File No: 425NTH10/00230 10/2528
Your reference: MP10_0176
Mr Gregory Sciffer

NSW Department of Planning, MP 10_0176, Tamworth Regional Cancer Centre.

I refer to your letter dated 24 November 2010 and the Roads and Traffic Authority (RTA) email advice dated 8 November 2010 for the proposed development. As previously stated, the RTA has no objection in principle to the proposed development.

TITLE:
CIRCULATION PLAN
SCALE:
1:500
DATE:
12. Nov. 2010- 22.03.11

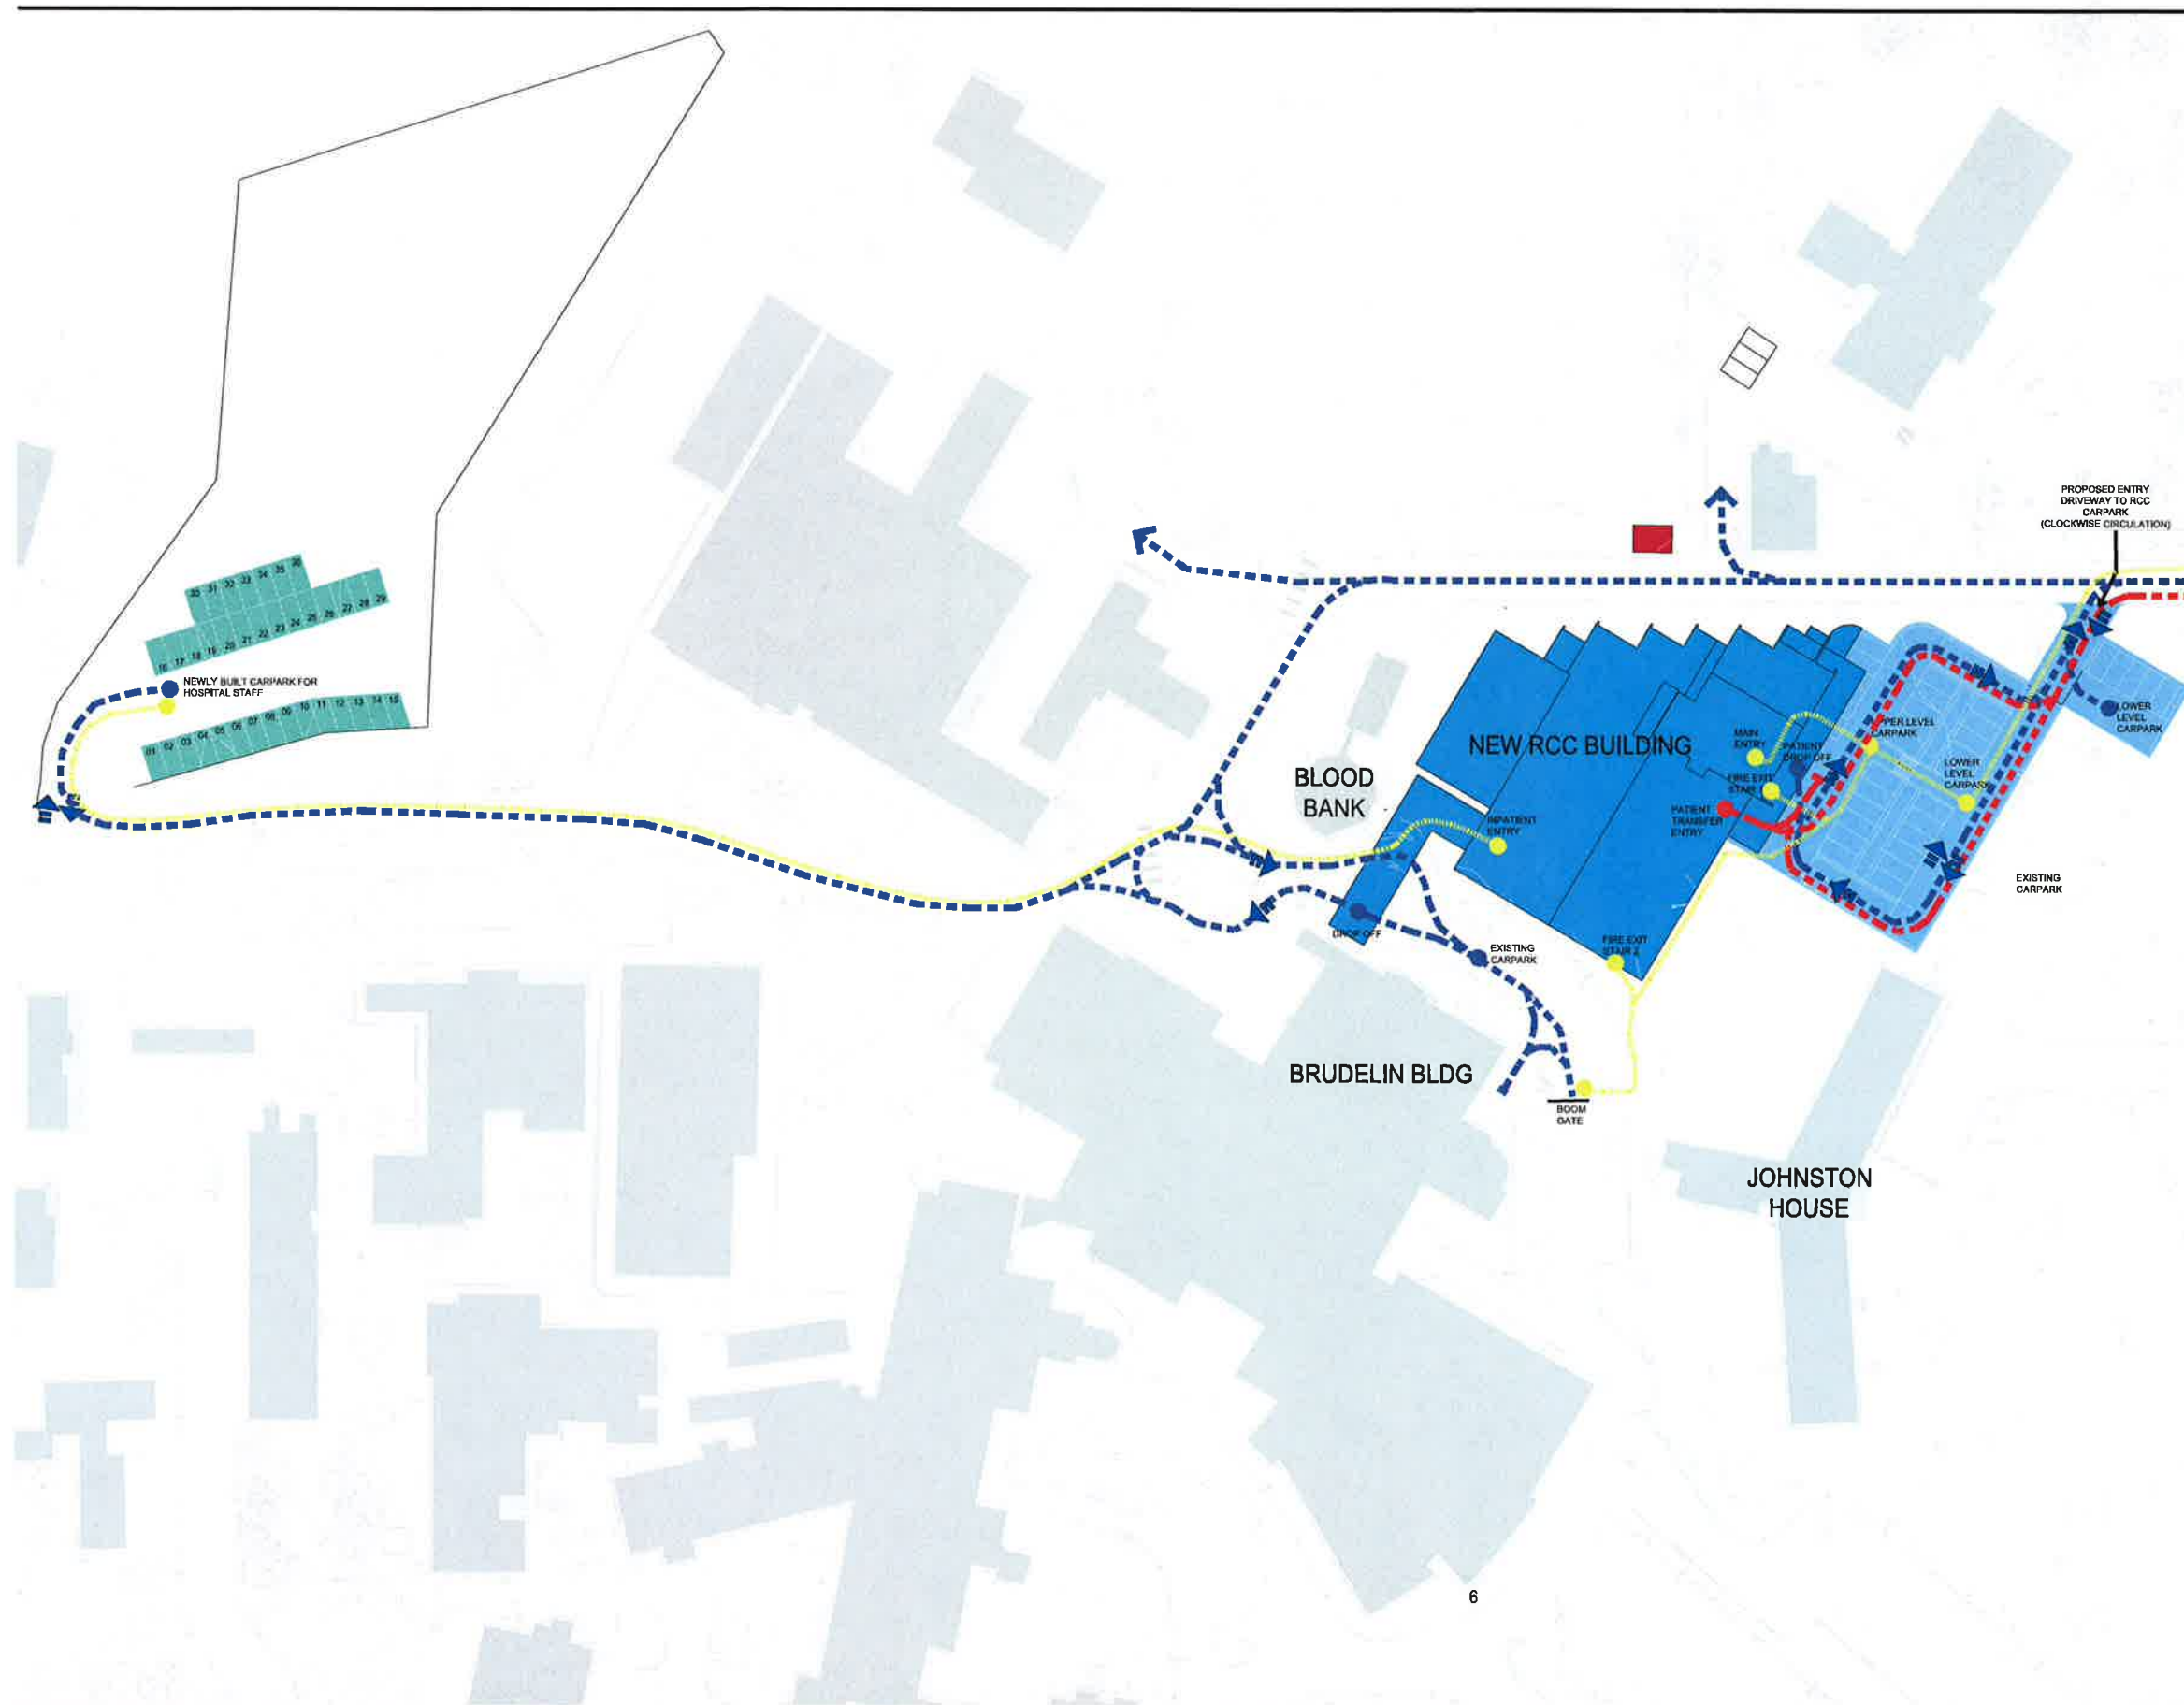
- i. It is obvious from the on-street parking demand that there are problems associated with the management of the off-street parking for the hospital.
- ii. It is not clear how or where the additional staff parking will be accommodated.
- iii. Staff shift changes generate a significant overlapping demand for additional parking.
- iv. In accordance with the Road Related Area regulation any standard regulatory device installed in a place open to the public such as parking controls and pedestrian crossings need to be approved by the local traffic committee. If not they are unenforceable.
- v. A number of the RTA's previous comments related to the safe and efficient operation of the proposed cancer centre's parking area. None of these appear to have been addressed. Parking should operate in a clockwise direction so patients are dropped off and picked up on the kerbside.
